Re: Planning Application No 3/2020/0353, 2 Pendle Street West, Sabden BB7 9EG

Further to our brief telephone conversation on 24th June, I wish to submit representations regarding this proposal and would also like to apply to speak at the planning and development committee meeting when the members sit to consider the application.

Existing Roof Elevation From Rear Alley

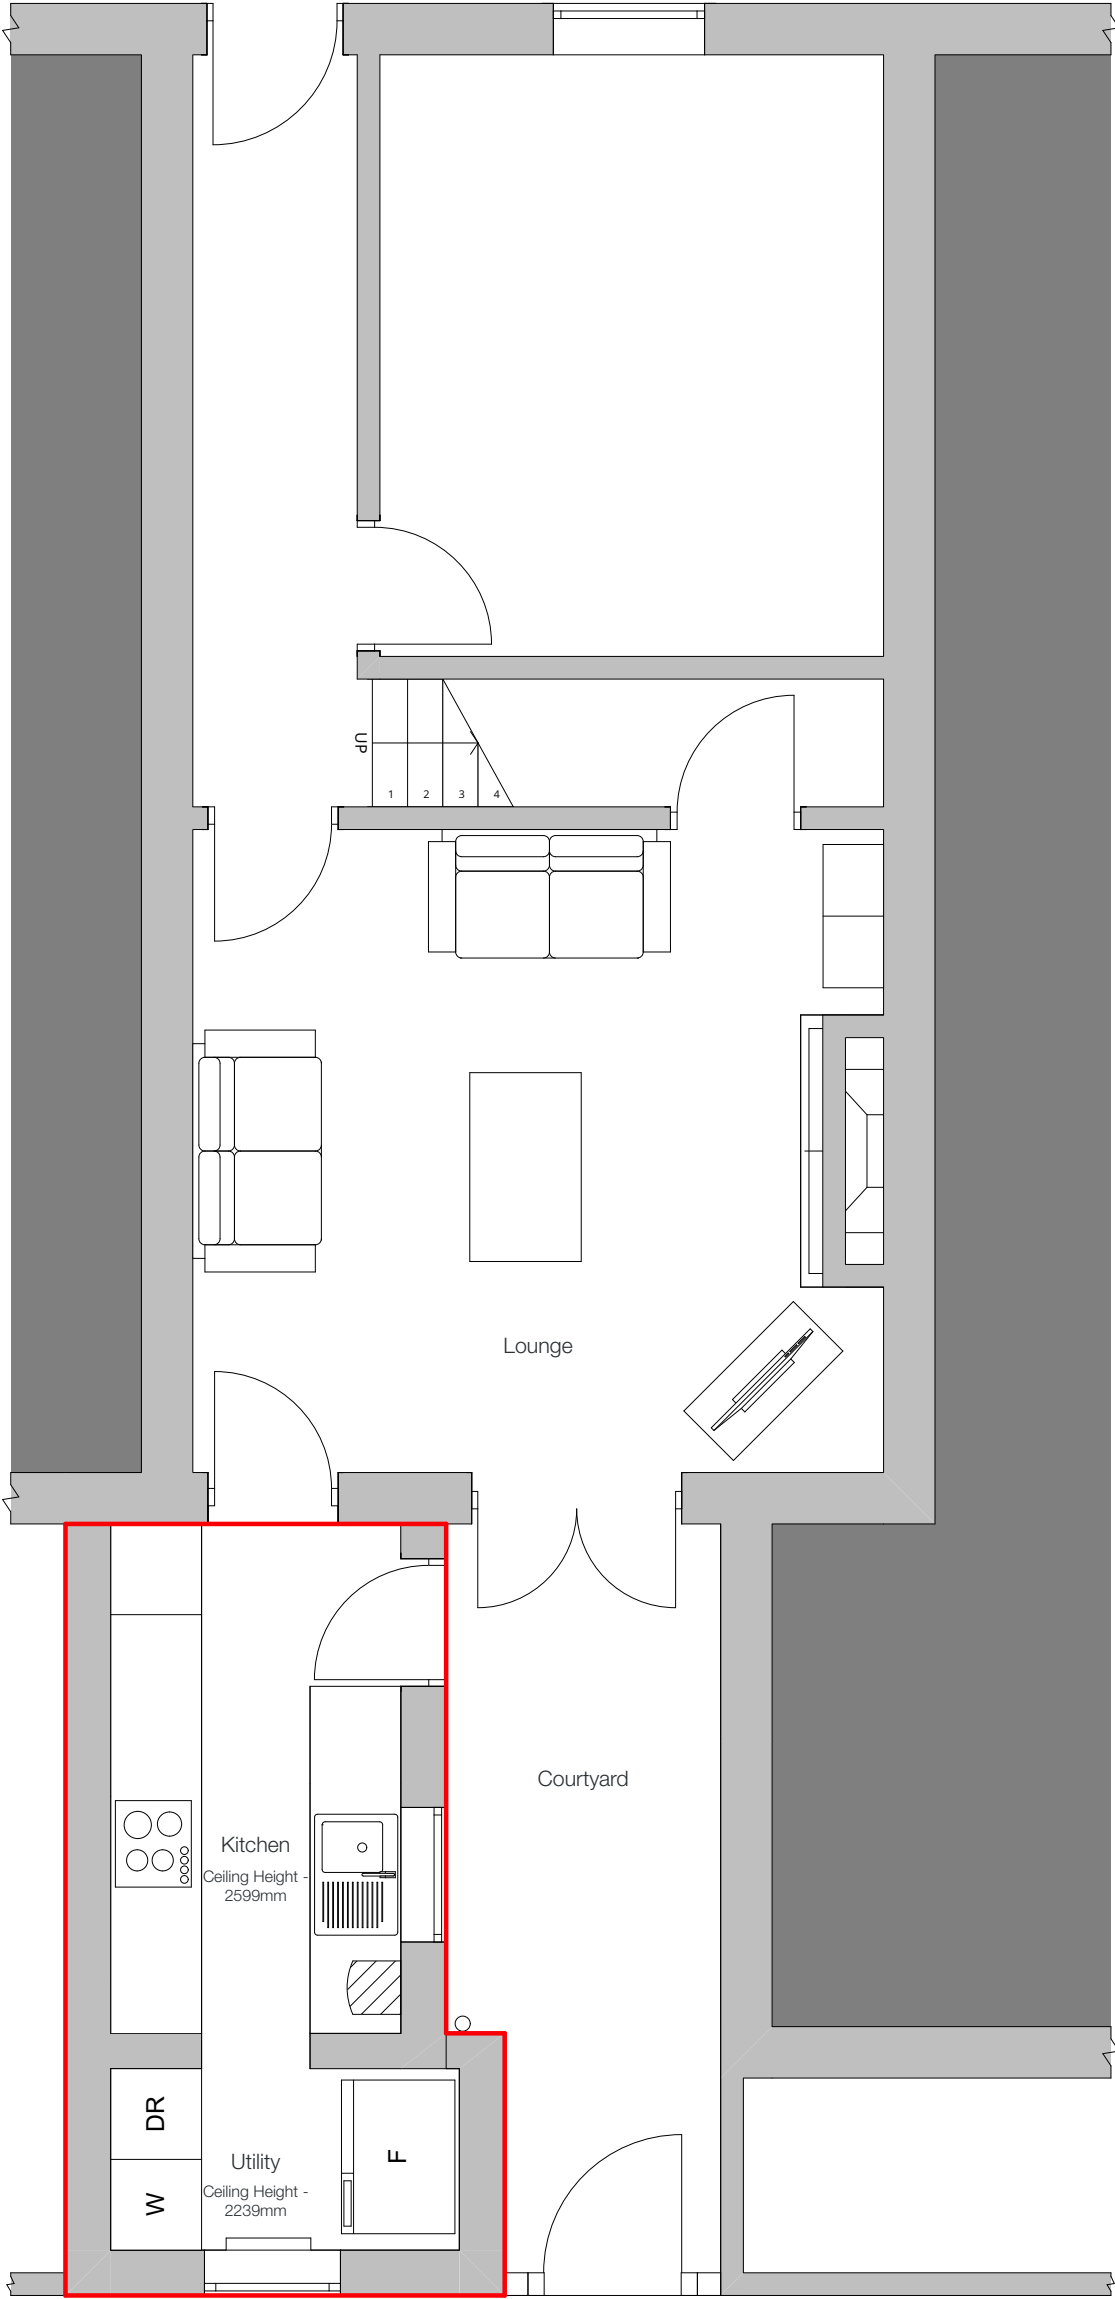
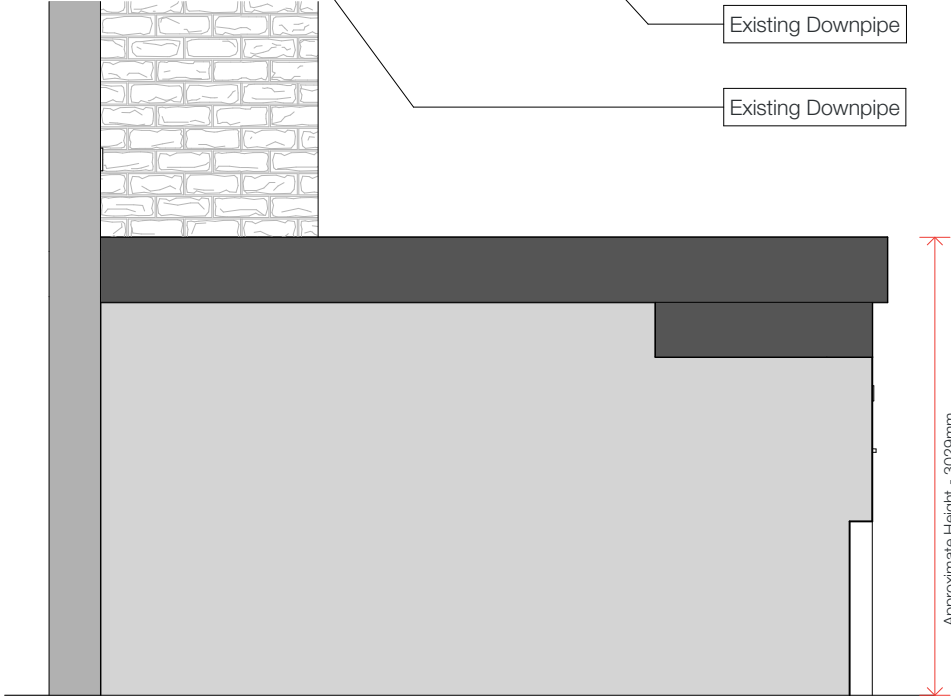
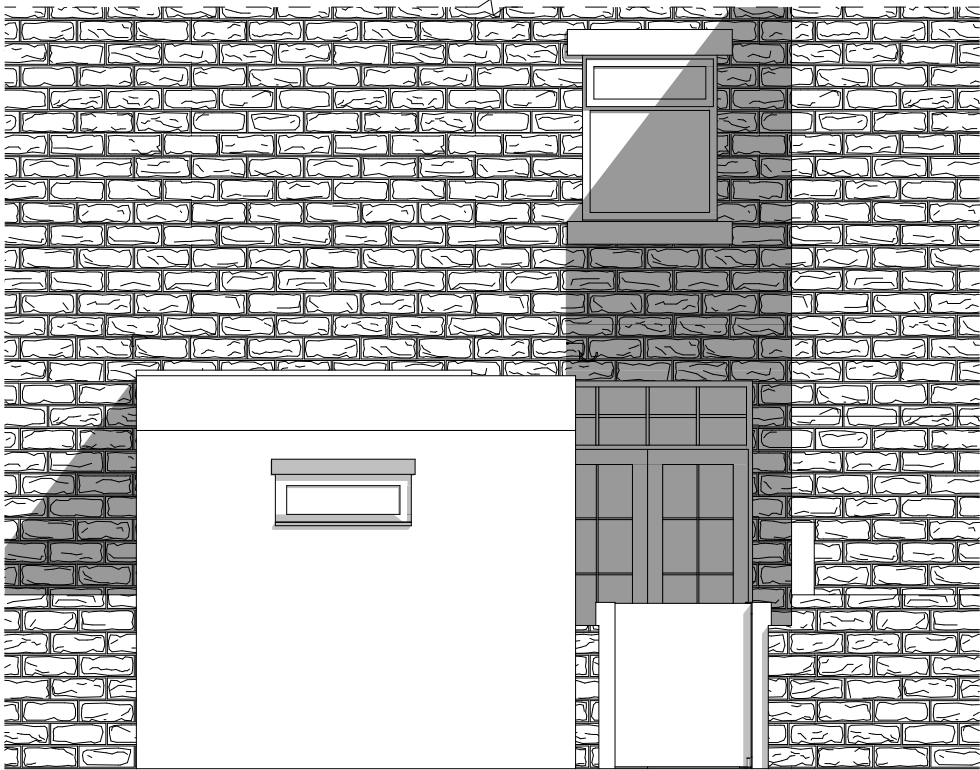
Existing roof elevation from back alley – this is not an accurate reflection of how the structure looks currently and is not how it looked before Jigsaw Homes installed what is currently in situ. The drawing seems to suggest that the current replacement roof structure does not overhang my boundary which in fact it does, quite significantly.

Drawing Title	
Proposed Roof Plan and Elevation	
Project	
2 Pendle Street West, Sabden	
Client	
Jigsaw Homes Group	
Scales @ A3	First Issue Date
1:50	08/04/2020
Job Number / Dwg. No. / Revision	RIBA Stage - Drawing Status
L2980_GA03	[3] - Planning
Drawn	Check
JS	BY

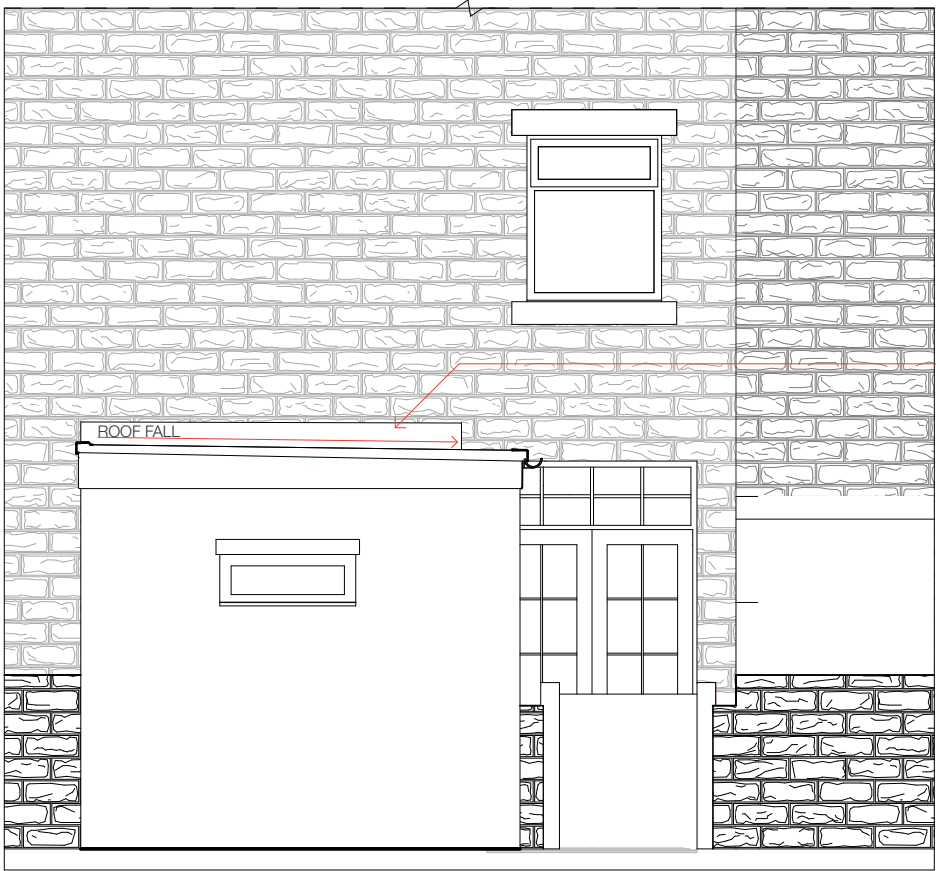
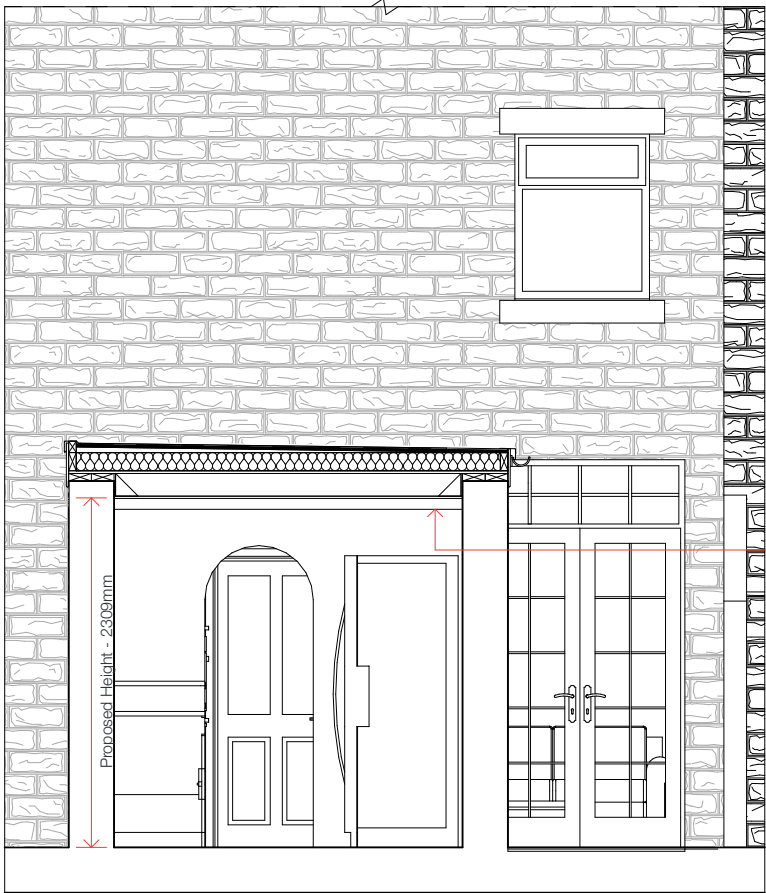
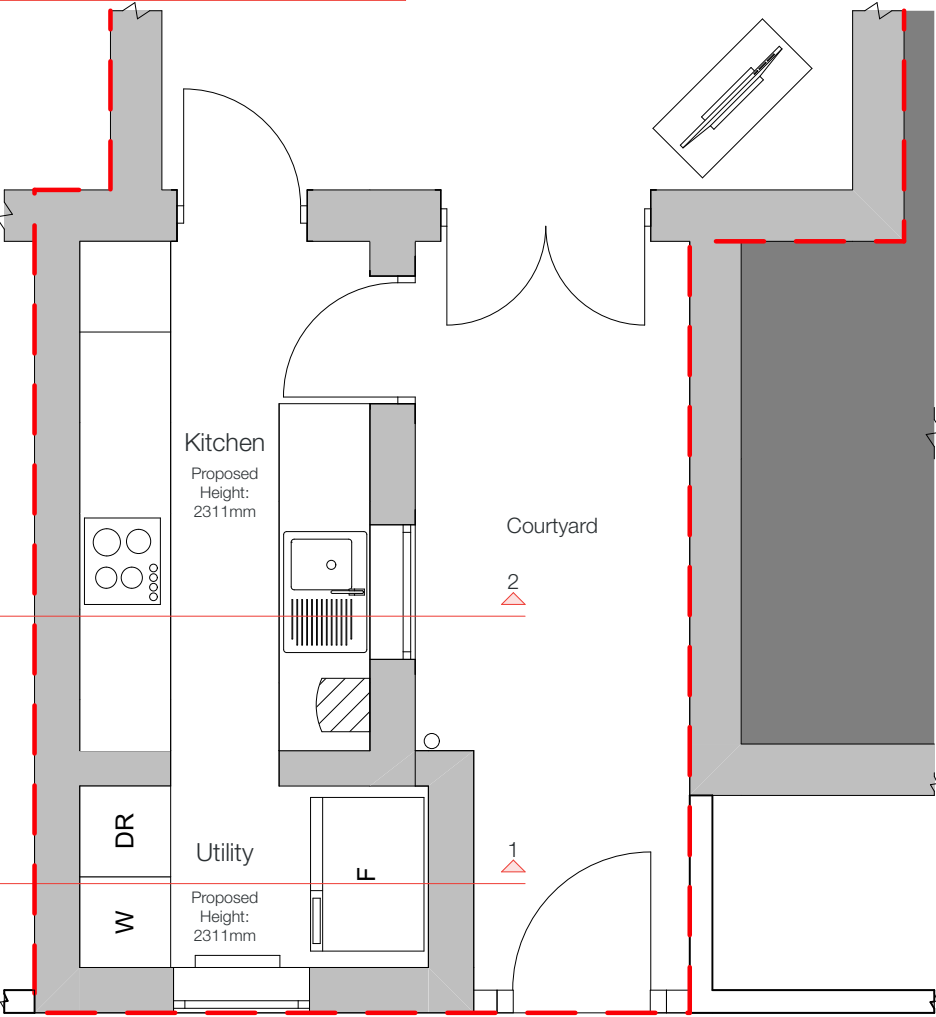
Much of the information within this document are based on approximation and assumption as follows:

Approximate 340mm roof reduction

Existing roof height and assembly is to be verified

Presumed resident boundary

New fascia board to match existing (fascia board in situ now does not match the roof removed prior to this application, and has been clumsily fitted above historic material causing an unsightly mismatch). I would like clarity on how the HA intend to couple the replacement roof to the existing material on my boundary (photo provided).
